ATTACHMENT 1

In order to finalise the Department's assessment, additional information is required including but not limited to the following:

FOR CONTINUATION REFER TO DWG. 18652\_SSDA\_BE01

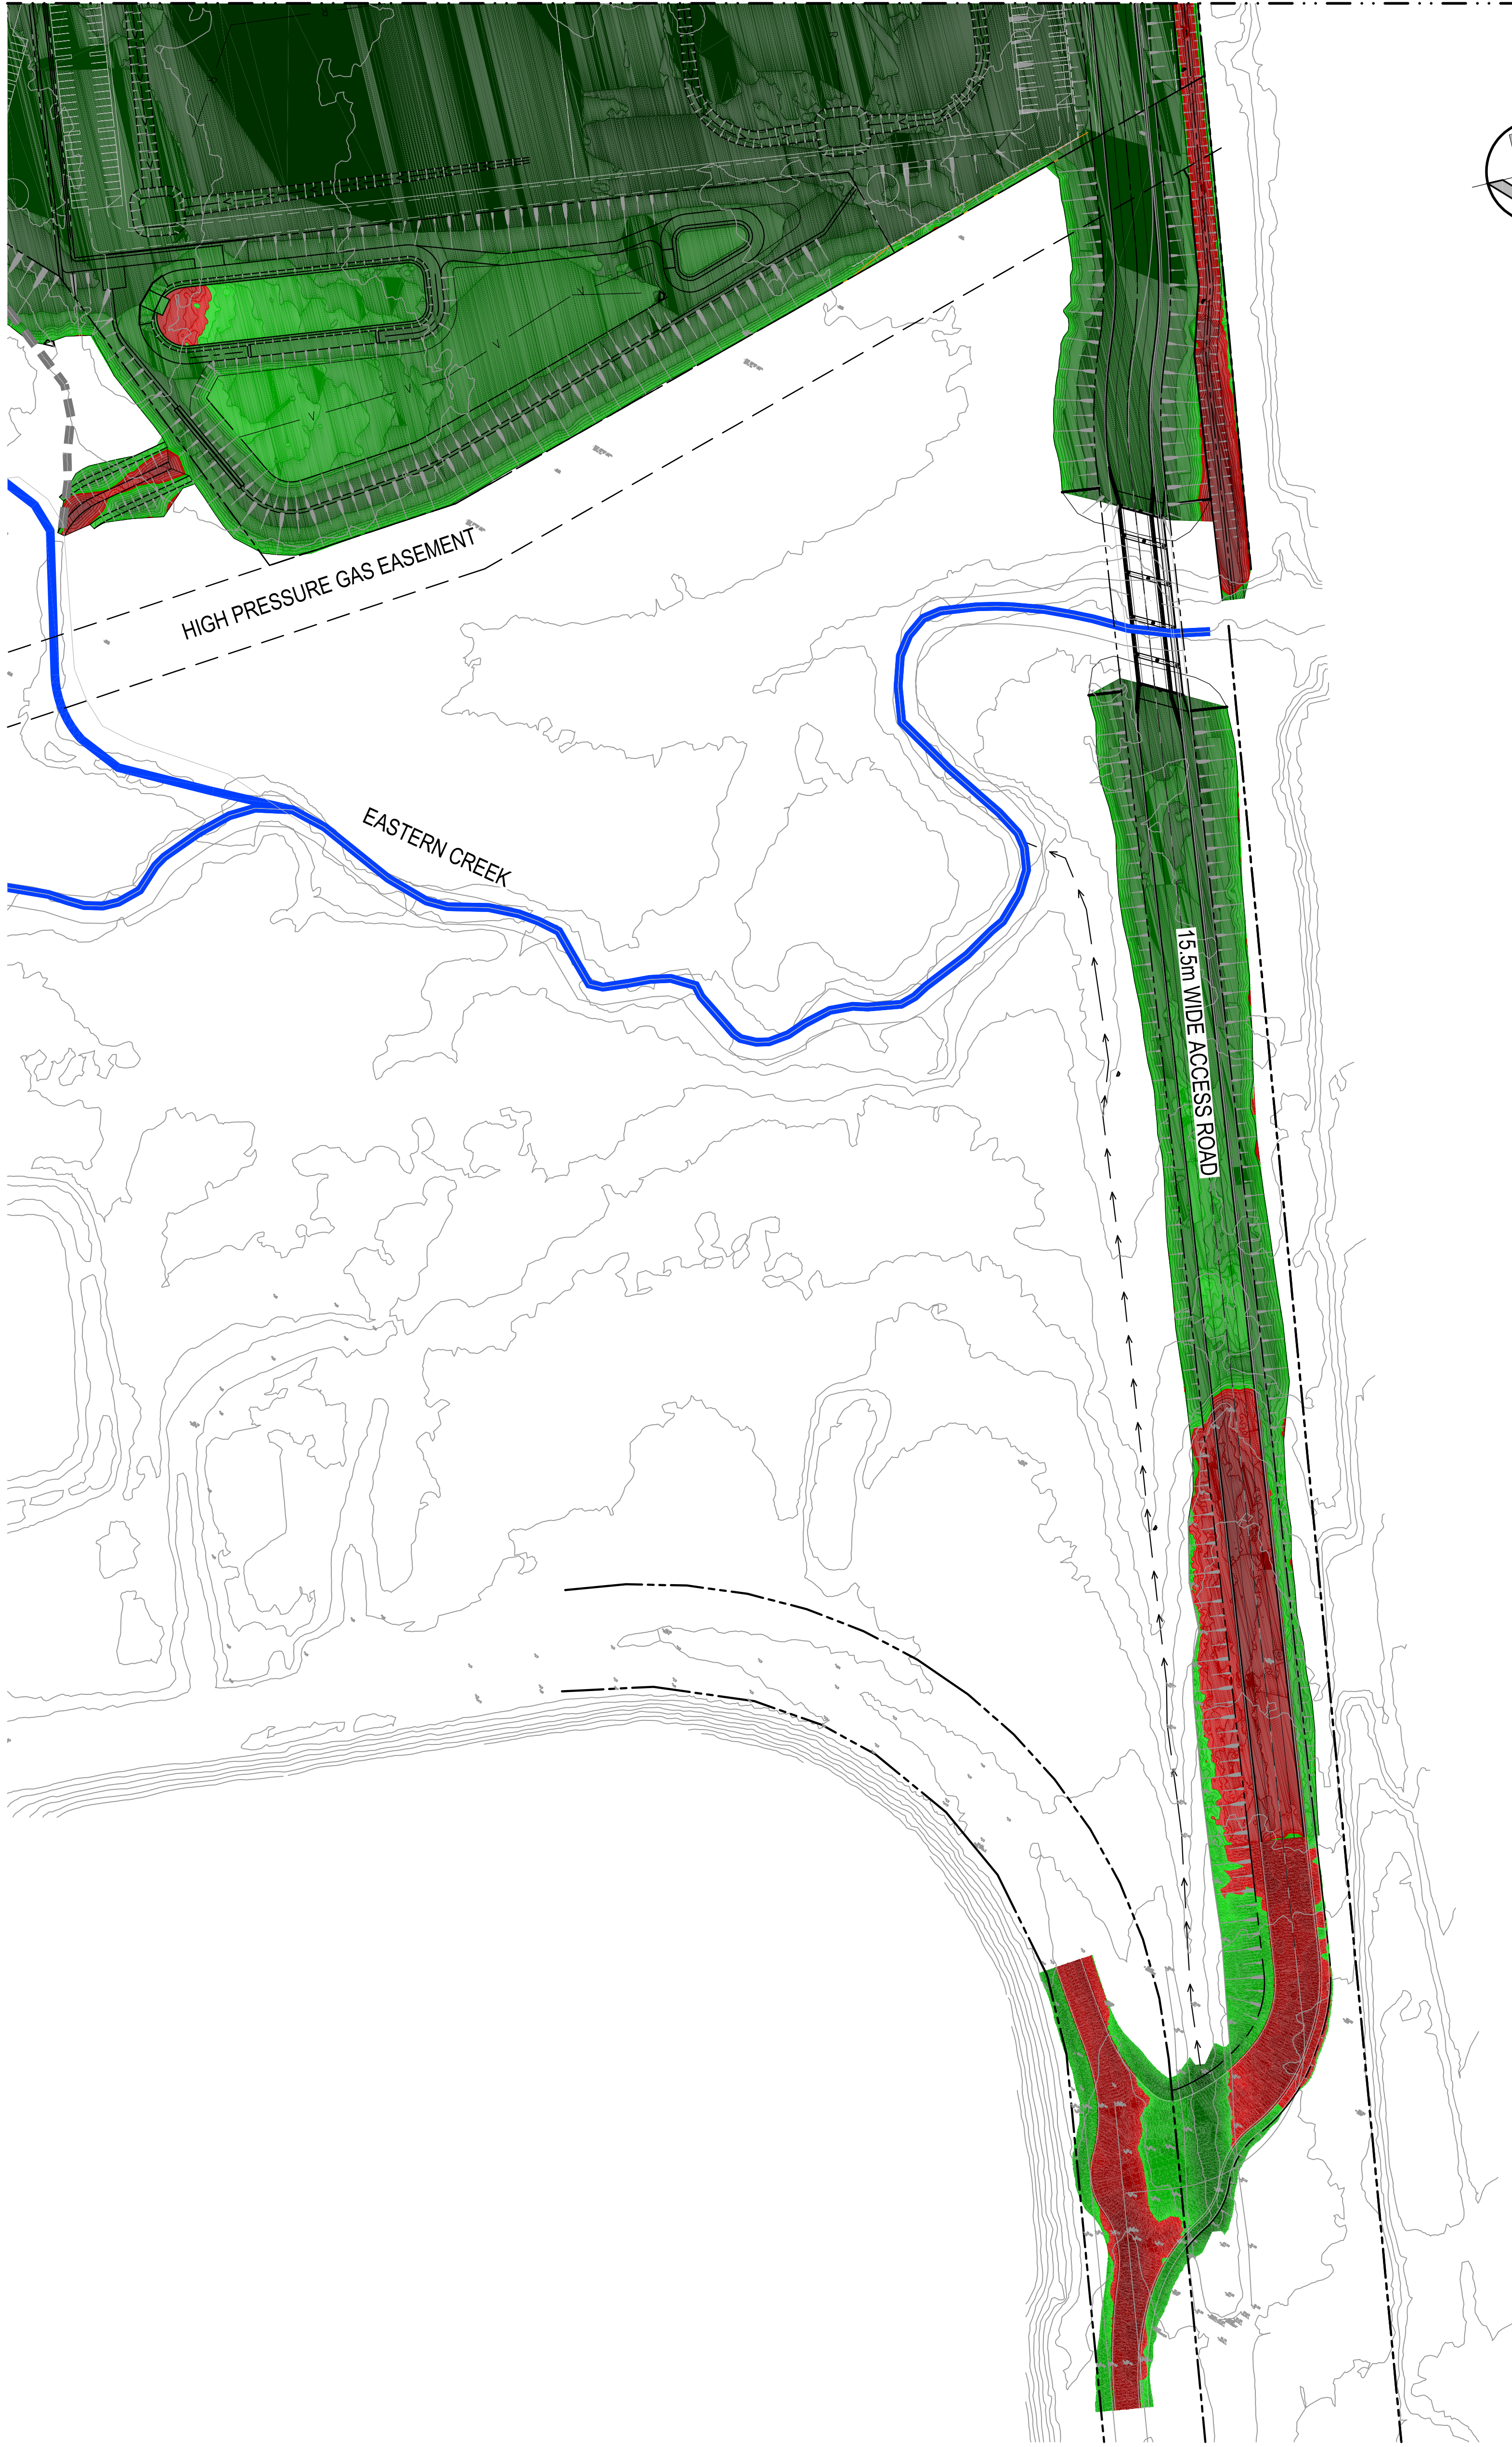
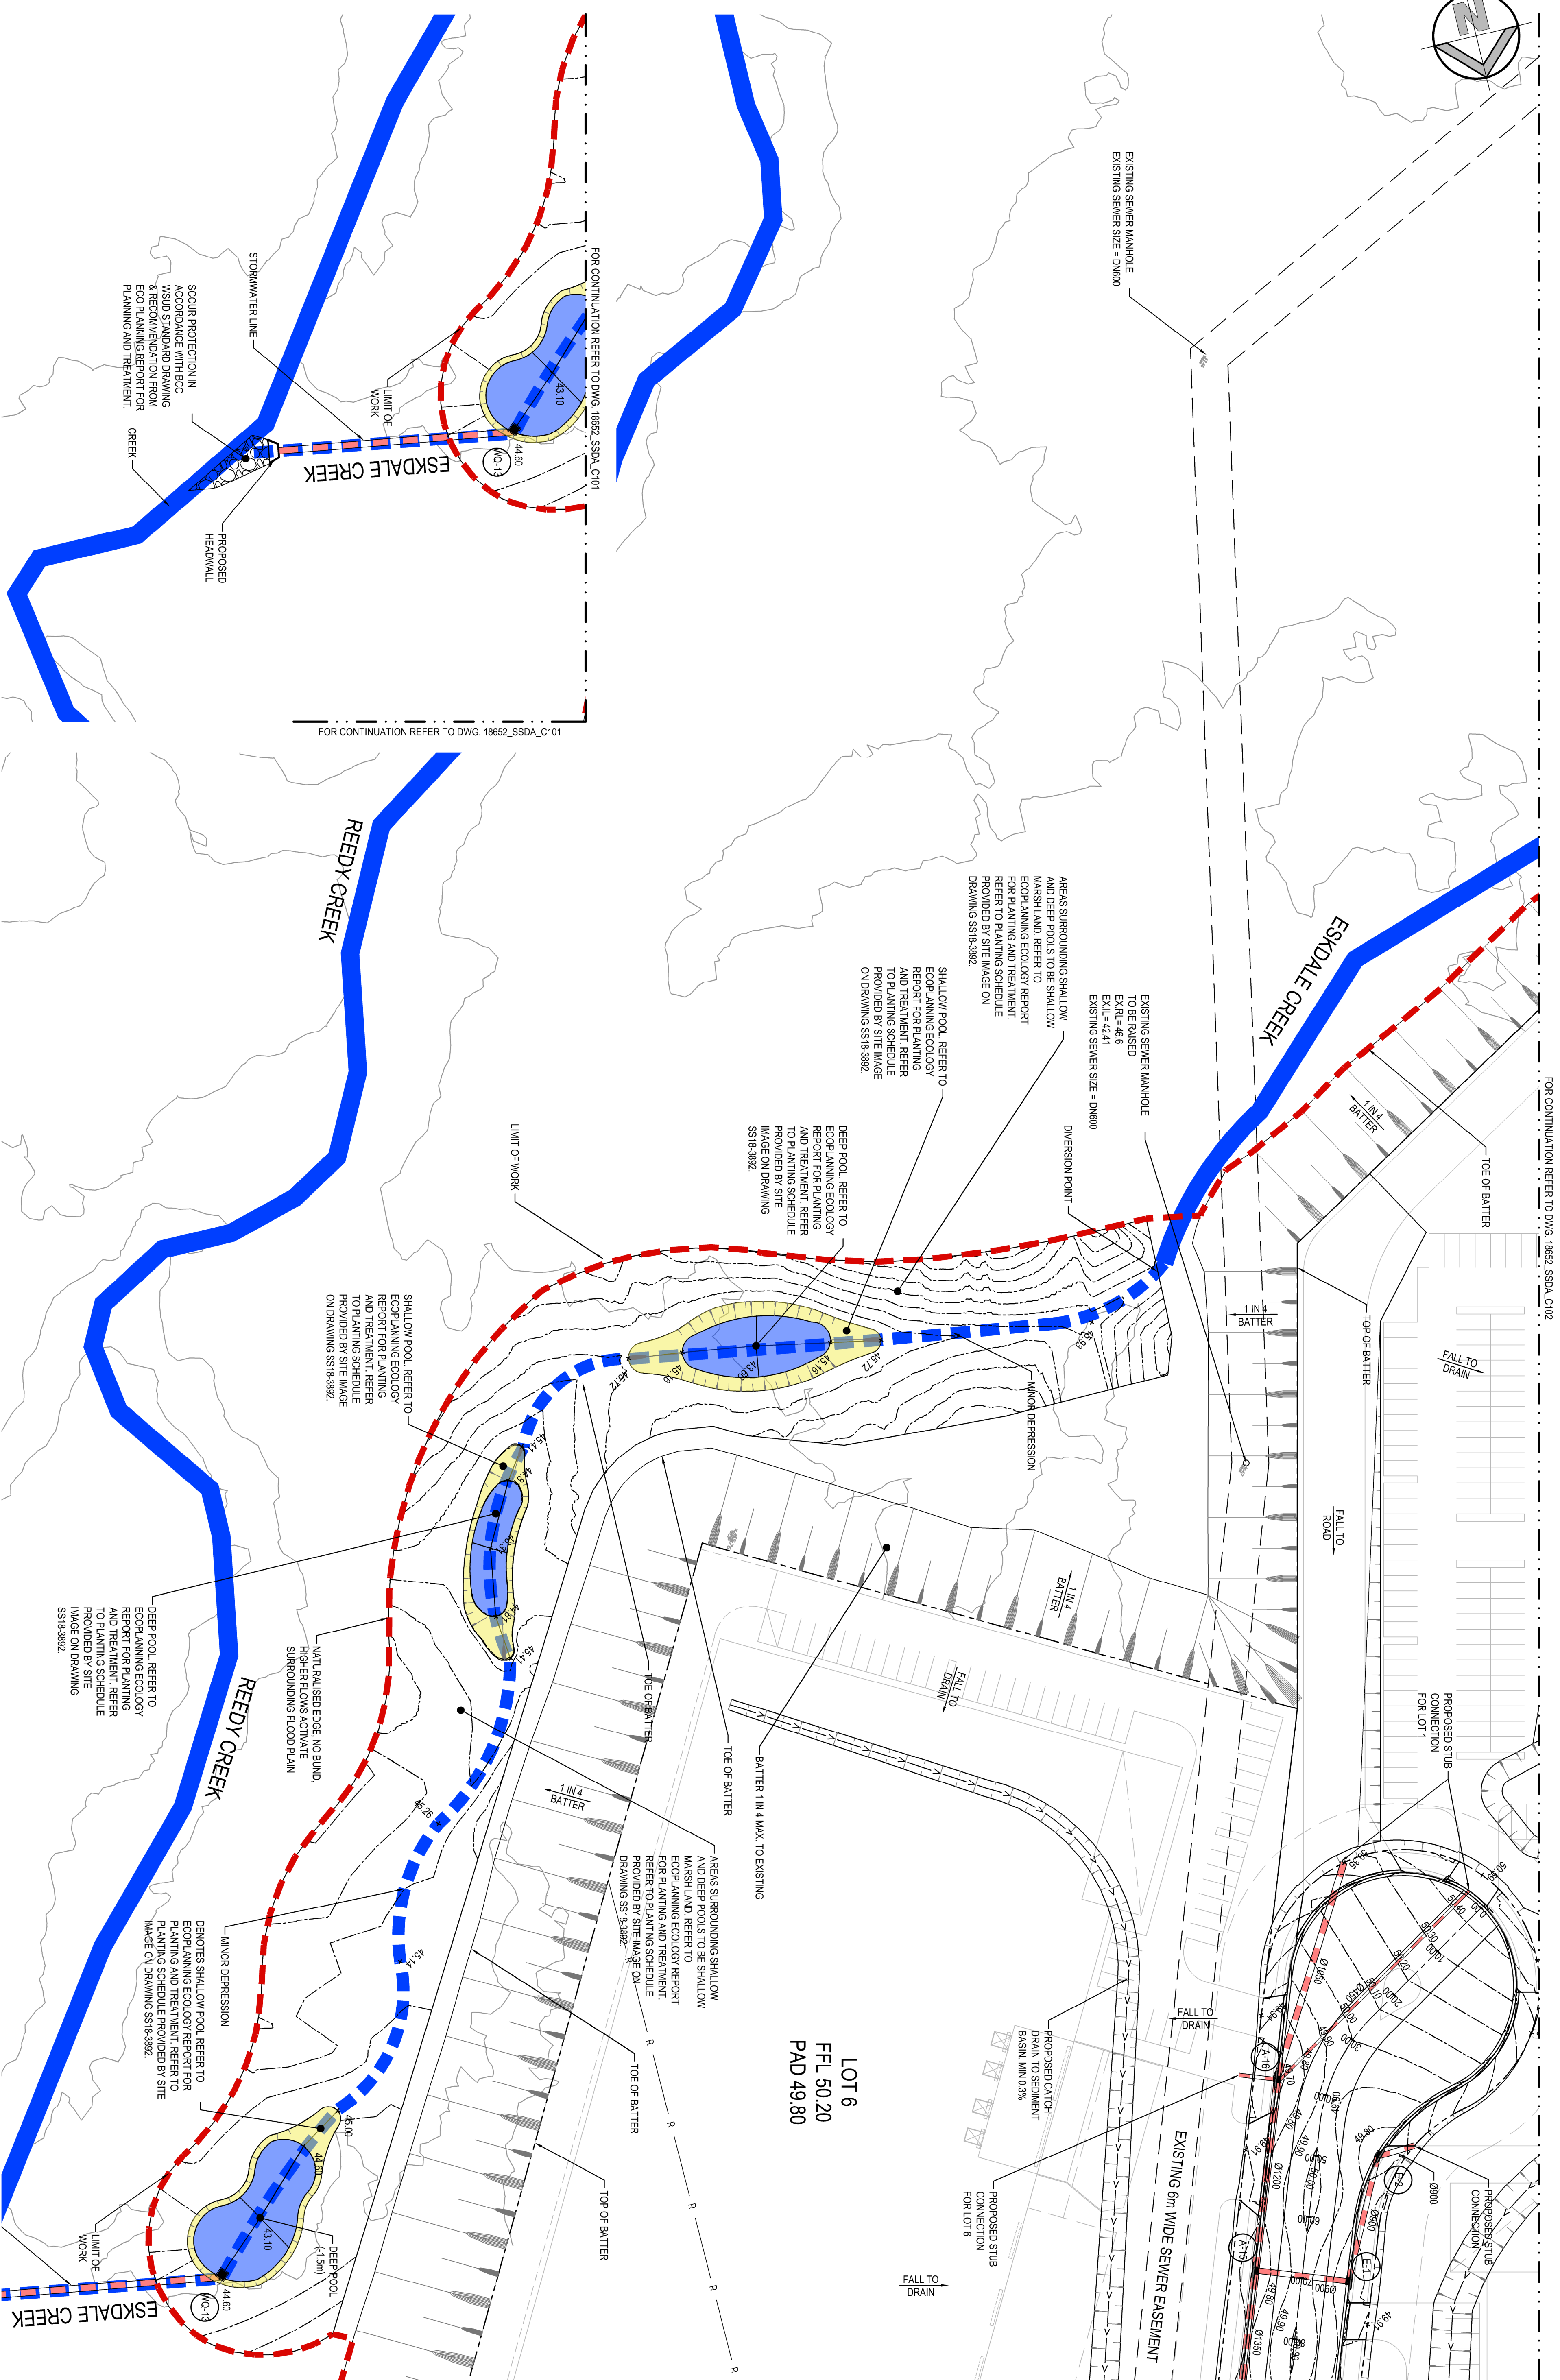
- The EIS identifies that approximately 905,000m³ of fill is to be imported (pg. 49). The civil engineering plans show filling of up to 6 m across parts of the site. Further explanation and justification is required for the extent of filling proposed given the difference between the building pad levels and the 1 % AEP flood levels.
- The site survey (Appendix D) provides contours demonstrating the fall across the site. It is requested that the plan is updated with spot levels for ease of comparison with the pad levels shown on the civil engineering plans.
